Planning Application Ref: **AW/140/18/T**

Location: **11 & 15 Waters Edge, Aldwick**

Description of works: Surgery to 4No. Monterey cypress trees

SITE BLOCK PLAN
Scale 1:500

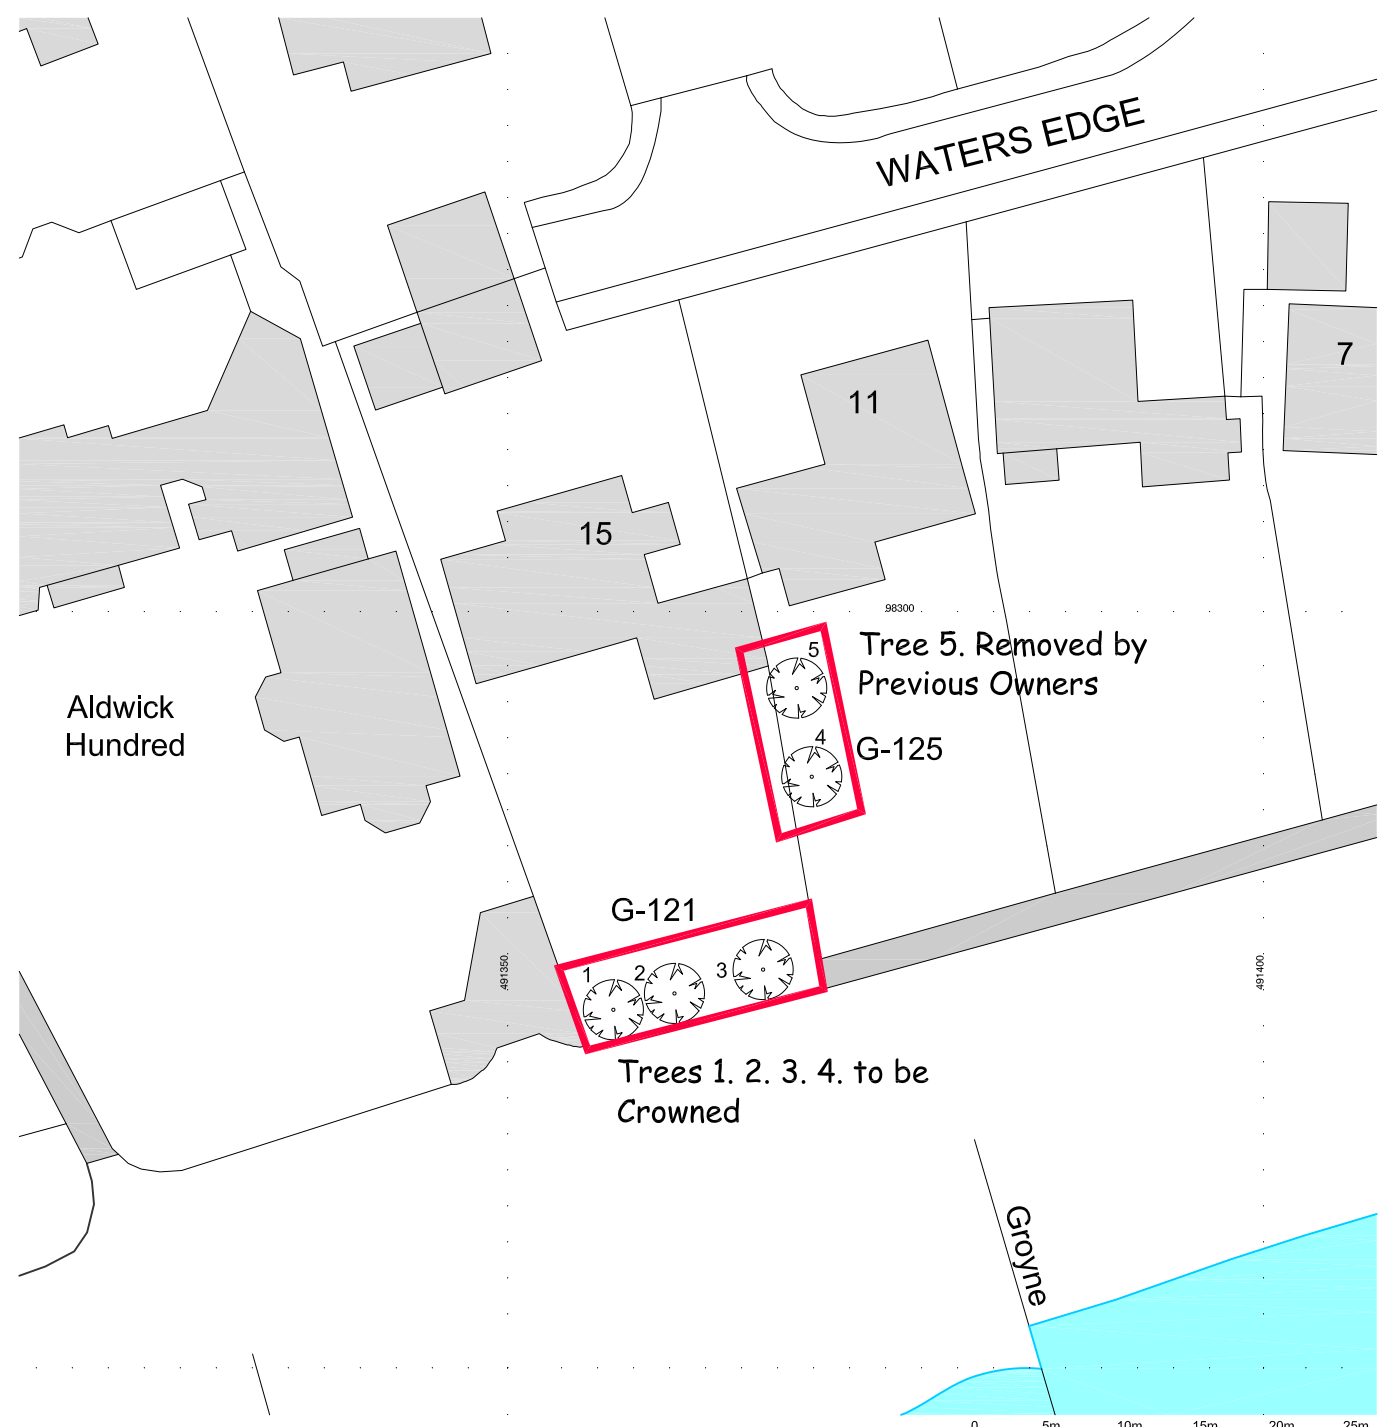
- This is a repeat application with revised specification (refer previous application AW/319/17/T – Refused).
- The four trees are situated in rear gardens and provide some visual interest to neighbouring property and shoreline visitors.
- They appear to be in a fine physiological state, albeit with reduced crown form and heavy exposure to salt-laden winds.

- This latest application better respects the tree's ongoing health and vitality, by retaining an adequate amount of foliar mass.
- If the work is undertaken precisely and does not exceed the upper limit of proposed branch reduction, then there should not be a notable loss of amenity value.

- I recommend **CONSENT** for this application, subject to the following condition:
- Where branches are to be shortened back the final cuts are to be made at the correct angle shown in BS3998:2010 and adjacent to a live bud or lateral.
